Item No. **Report of the Head of Development Management and Building Control**

Address: 58A STATION ROAD HAYES

Development: Erection of 2 additional storeys to create a flat at first and second floors above ground floor commercial unit.

LBH Ref Nos: 69395/APP/2025/797

NOTE

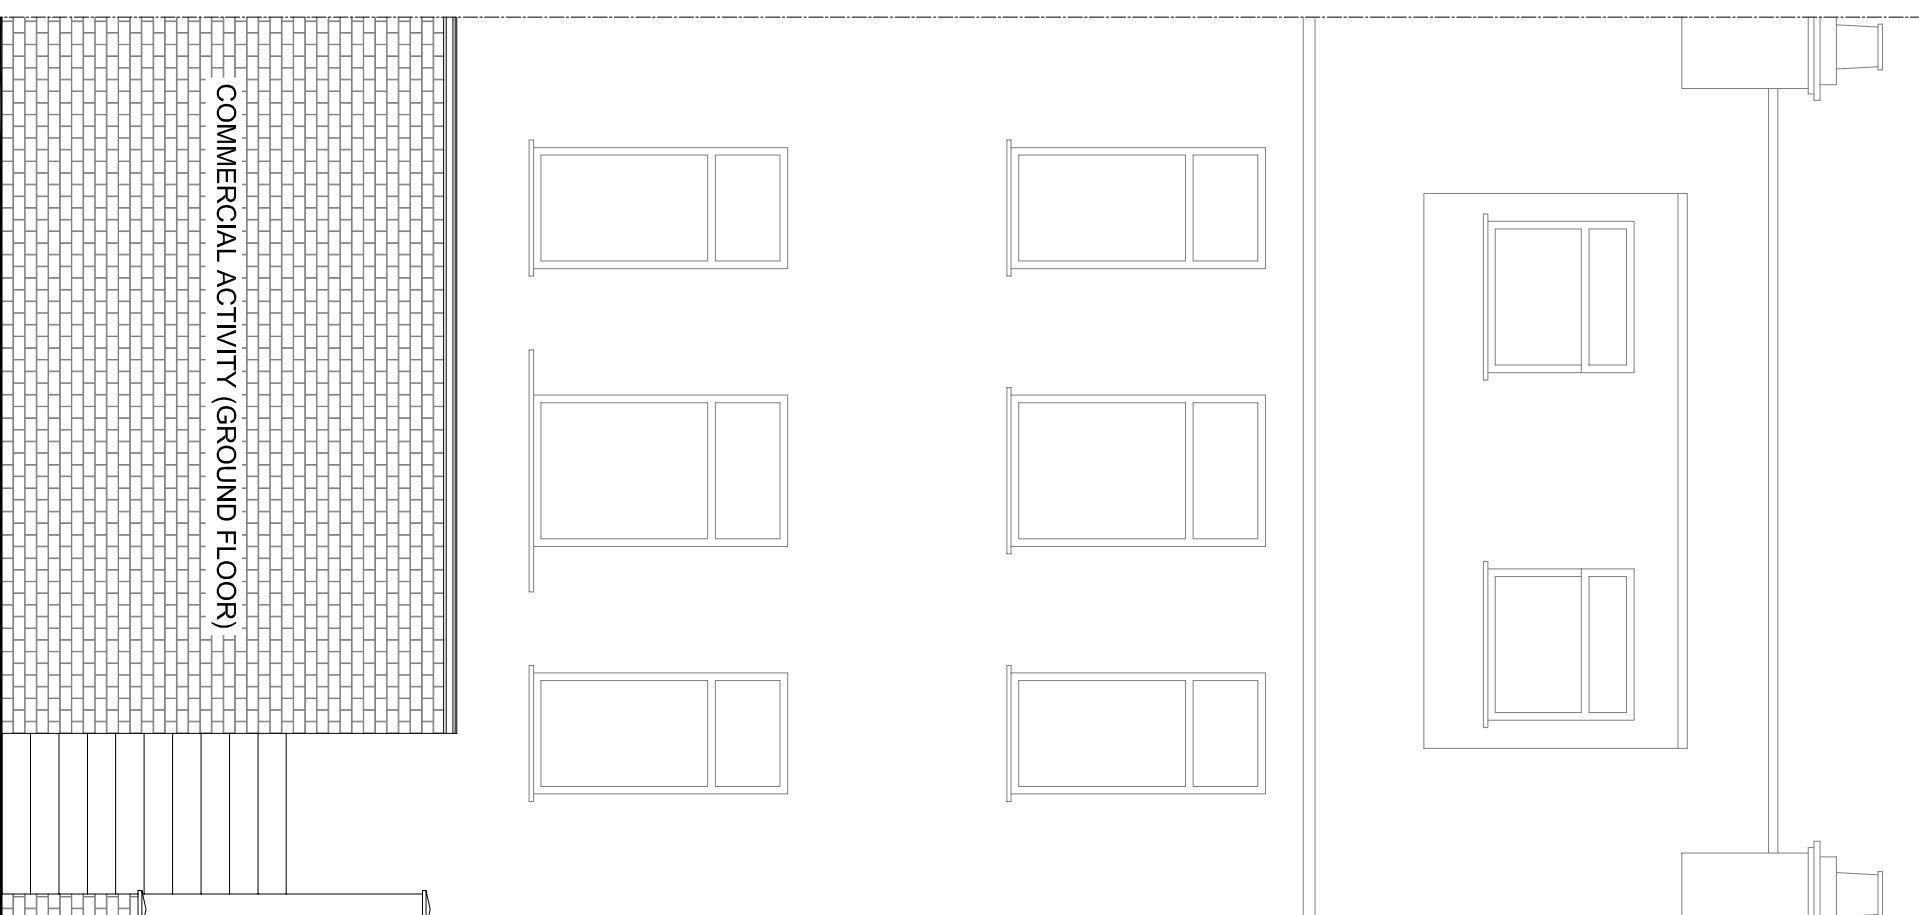
Relative to the previously refused scheme, the floor plans show the proposed second floor has been set back from the front elevation by 1.15m and has been redesigned with a flat roof. The proposed elevations show however both the first and second floor being set back, therefore the plans do not tally with the elevations.
